# Frodsham Solar

## Statement of Common Ground with the Environment Agency

April 2026

PINS Ref: EN010153  
Document Ref: EN010153/DR/8.17  
Planning Act 2008; and Infrastructure Planning (Applications:  
Prescribed Forms and Procedure) Regulations Regulation 5(2)(q)

April 2025

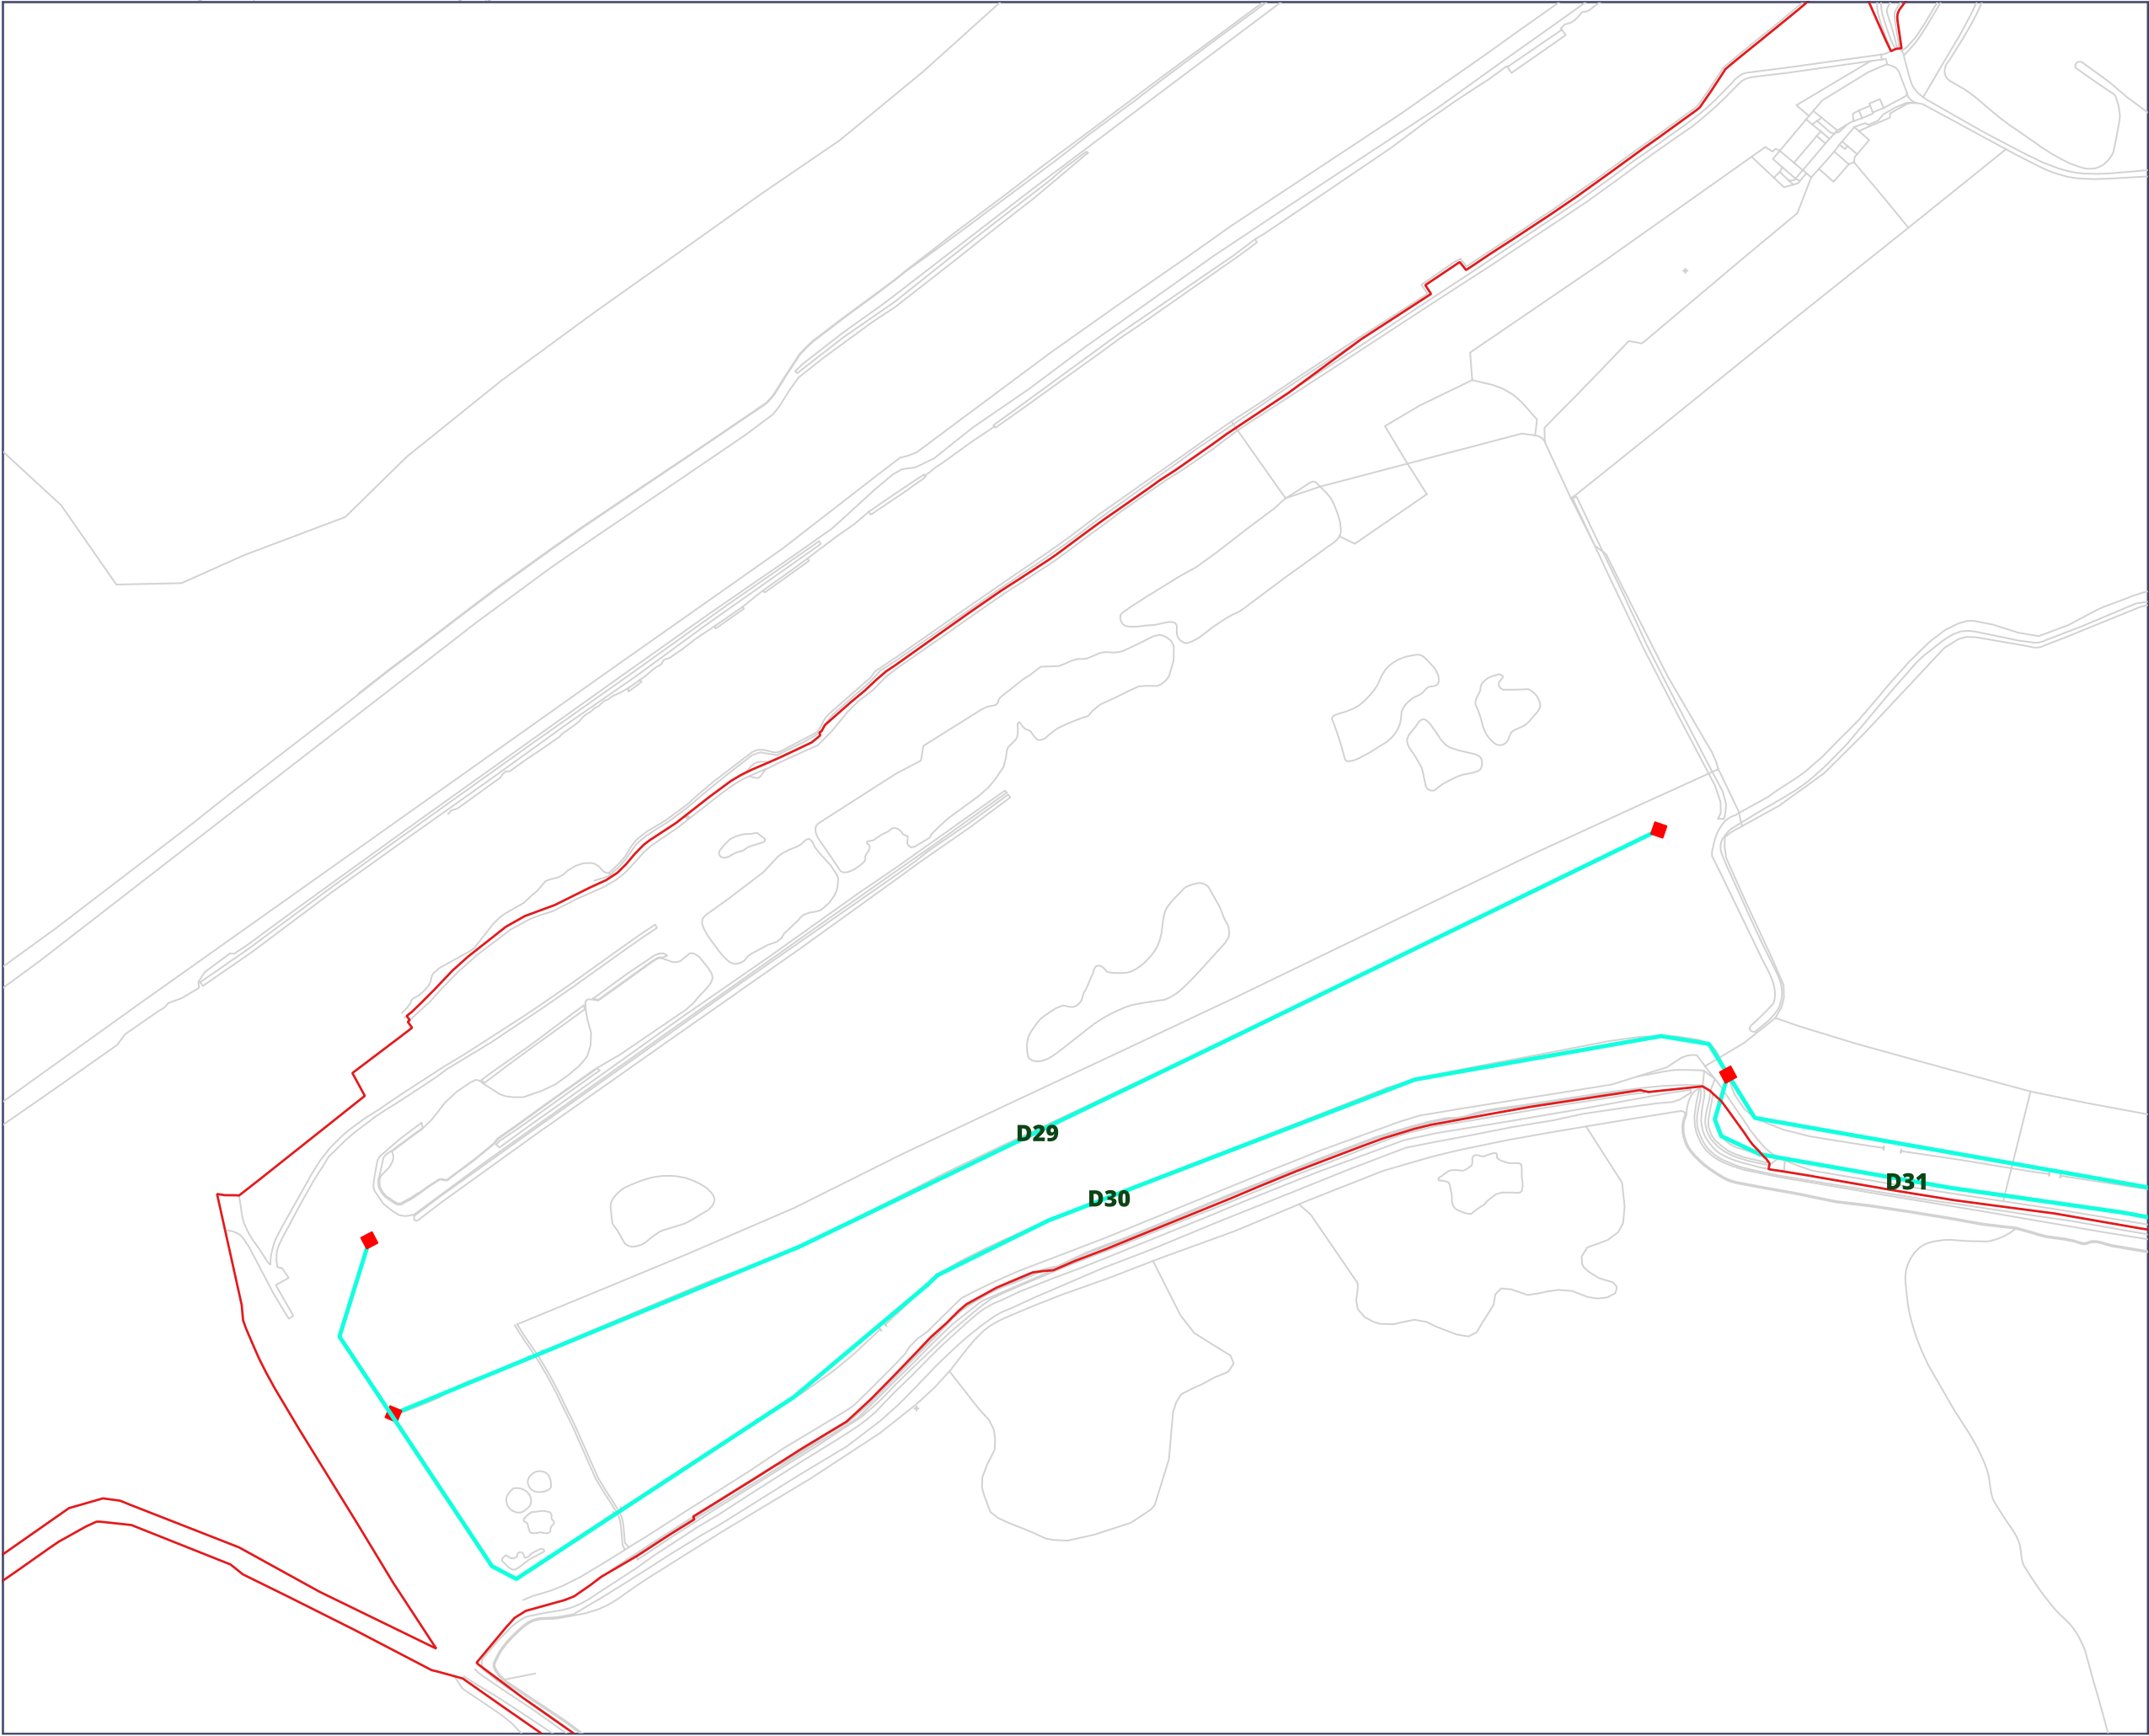
Ref.	Matter	EA Position	Applicant Position	Status
012	<p>The Applicant's approach to designing watercourse crossings.</p> <p><i>EA Issue ID: EA007</i></p>	<p>The EA has concerns about the position of bridge abutments and soffit levels, and that these will reduce conveyance of water during high flow conditions, preclude access to, and threaten the stability of the riverbanks.</p> <p>The EA request that a soffit level at least 0.6metres is provided from the bank top, as set out in the Standard rules SR2015 No 28 guidance. The EA require a 2m offset for the abutments to ensure that geomorphological processes aren't impacted.</p> <p>The EA has requested that the Applicant provides a 600mm freeboard between the bridge soffit and top bank level for CP14 and CP17, and a 300mm freeboard at CP21.</p>	<p>The Applicant has provided drawings for CP14, CP17 and CP21 demonstrating that the required freeboard can be provided.</p>	Matter Agreed.

Appendix C Flood Evacuation Route Plan

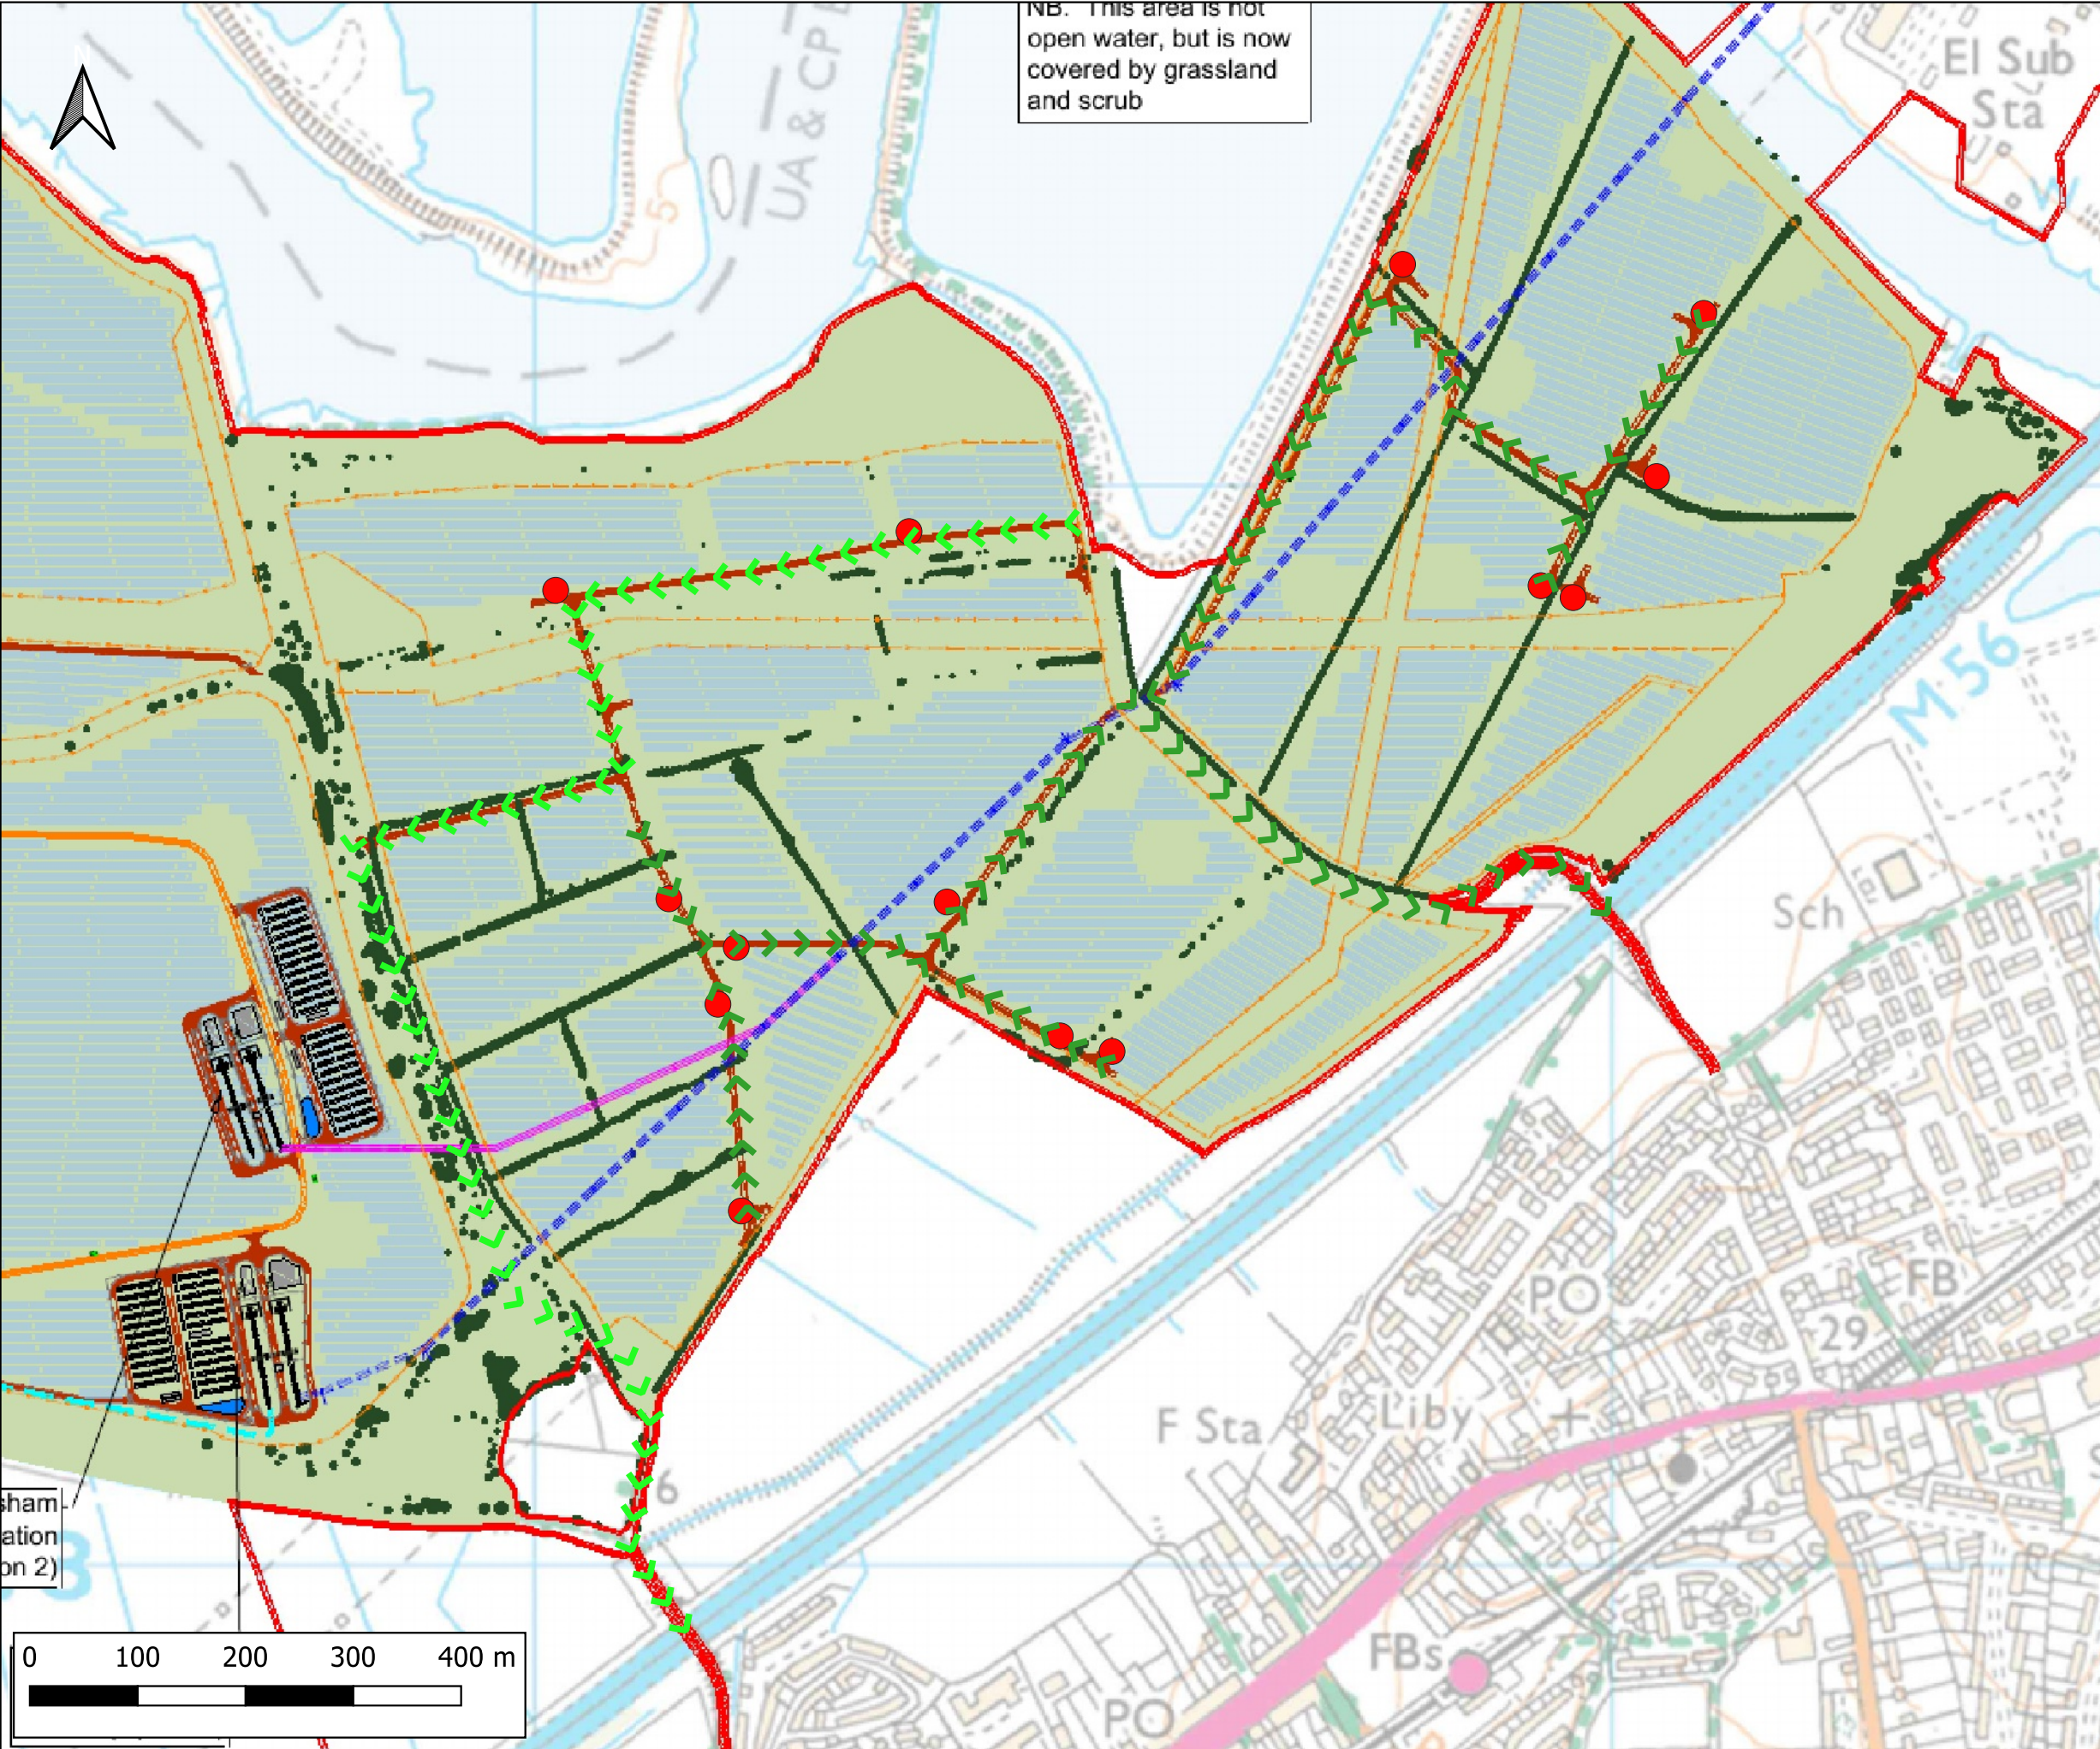
Ref.	Matter	EA Position	Applicant Position	Status
		<p>dry egress routes. The applicant needs to consider the duration of the flood event.</p> <p>The EA note the additional public rights of way (PROW) proposed. The risk to members of the public may also need to be considered within the evacuation plan.</p>	<p>Warning. Therefore, there will be no staff on site to evacuate when flooding occurs.</p> <ul style="list-style-type: none"> <li>Any staff already on site will evacuate on receipt of flood / weather warnings, or if flooding occurs without warning.</li> <li>Safe refuge areas on site are provided as a last resort and failsafe.</li> </ul> <p>Any permissive paths would be closed on receipt of weather / flood warnings (with signage put up to alert the public).</p> <p>The areas of safe refuge (raised inverter / transformer areas) are set 600mm above the Mersey 0.5% AEP plus Upper End climate change flood level. They are also above all fluvial and tidal breach flood levels. Further raising i.e. above a H++ event is not considered necessary (as the H++ event is not a design flood event) as discussed in the meeting and subsequently agreed with the EA.</p> <p>The outline Flood Warning and Evacuation Plan was updated at Procedural Deadline B to reflect the outcomes of the meeting with CWACC Emergency Planning Team and the</p>

Ref.	Matter	EA Position	Applicant Position	Status
			<p>EA and is provided as document PD2-028 (noting that this is a revision of the outline Flood Warning and Evacuation Plan included as Appendix M to the Flood Risk Assessment (AS-027).</p> <p>The Applicant understands this matter is now resolved and can be marked as agreed.</p>	
014	<p>The Applicant's approach to designing watercourse crossings.</p> <p><i>EA Issue ID: EA010</i></p>	<p>The EA has concerns about the risk of the site not remaining operational in some design event scenarios, due to bridges being submerged and debris damaging crossings and embedded cables. Potential legacy issues with cabling in crossings if not removed during the decommissioning phase.</p> <p>The EA note that the Internal Drainage Board will need to be consulted on proposed crossings over non-main rivers.</p>	<p>The proposed main river bridge crossings will be designed with a soffit level 600mm above the top of bank level, and bridge abutments will be set 2m back from the bank, except for CP22 where maximum practicable clearance above the bank will be provided (as outlined in response to EA Issue ID: EA007).</p> <p>The Applicant has provided a technical note to the EA which considers the integrity of the proposed bridges in flood events in relation to uplift of the bridge deck, impact from floating debris and protection of service ducts. This sets out that:</p> <ol style="list-style-type: none"> <li>1. The self weight of the bridge deck, and supporting steelwork would be sufficient in resisting the uplift forces on the bridge</li> </ol>	Matter Agreed
